ABP-320705-24 (Knockshanvo Wind Farm & 110kV Substation)

VA03.320727 / ABP-317763 (110kV Grid Connection & Subsurface Cabling)

Date: 4th August 2026

We are writing to submit a formal observation directly responding to the planning statements and response to observations submitted by the applicant, FuturEnergy Knockshanvo DAC (prepared by MKO).

Reinstatement details based on Guidelines for Managing Openings in Public Roads - SD2

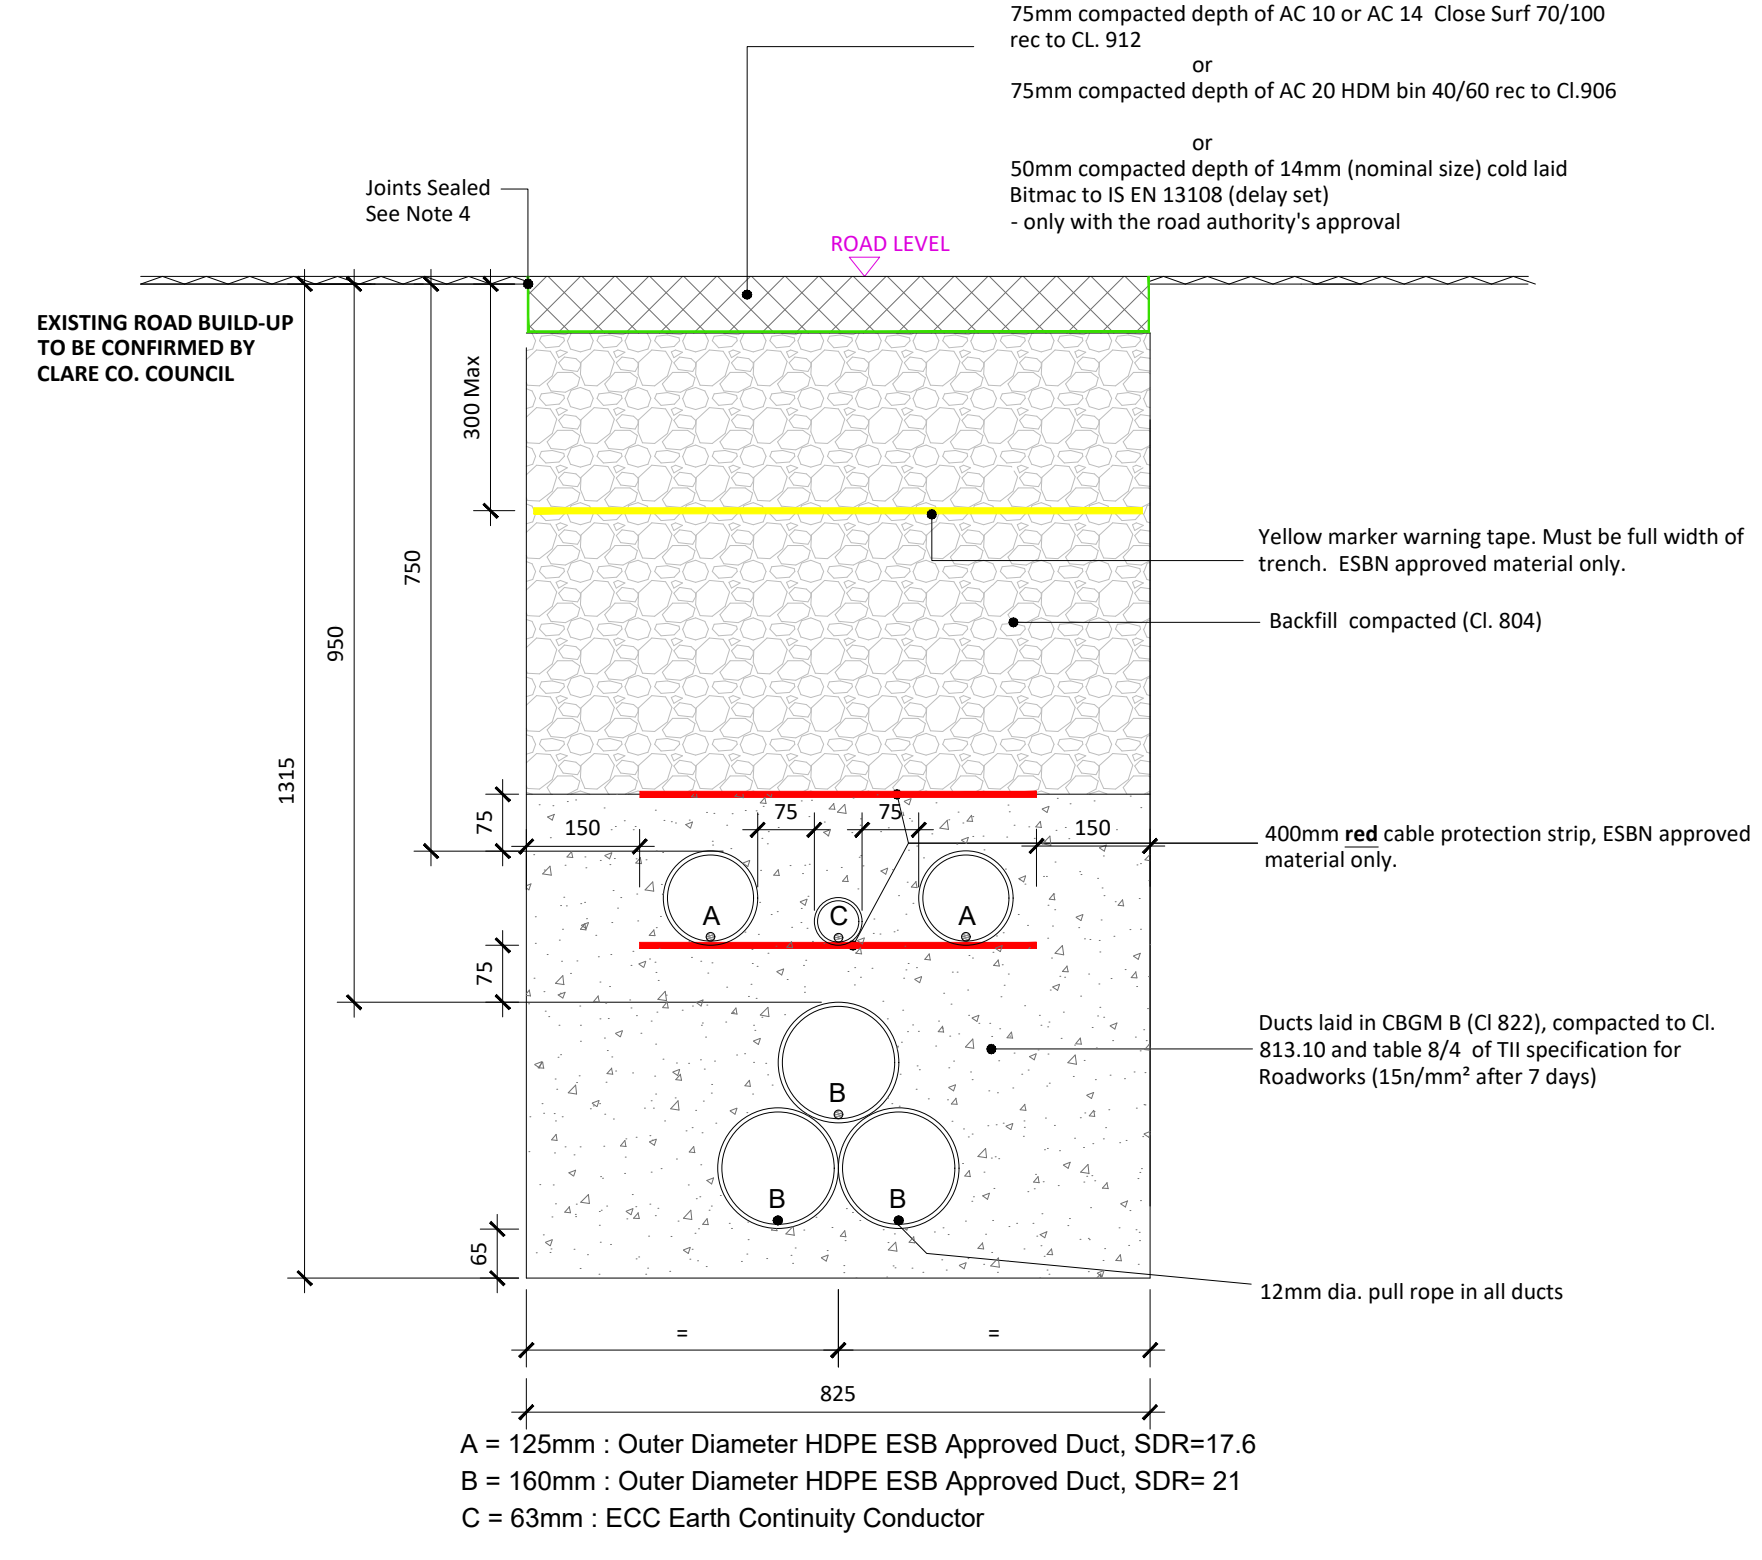
The Applicant's Position: The developer asserts that grid connection cable trenching along Sallybank Road (L3042) will cause only "temporary and short-term" construction disruptions, committing solely to standard pre- and post-construction road surface surveys for the local authority.

While MKO promises to restore the public road tarmac for Clare County Council, they have provided zero localized structural engineering assessments, zero baseline structural surveys, no vibration monitoring protocols, and no structural indemnity framework to protect our home against catastrophic cracking or subsidence.
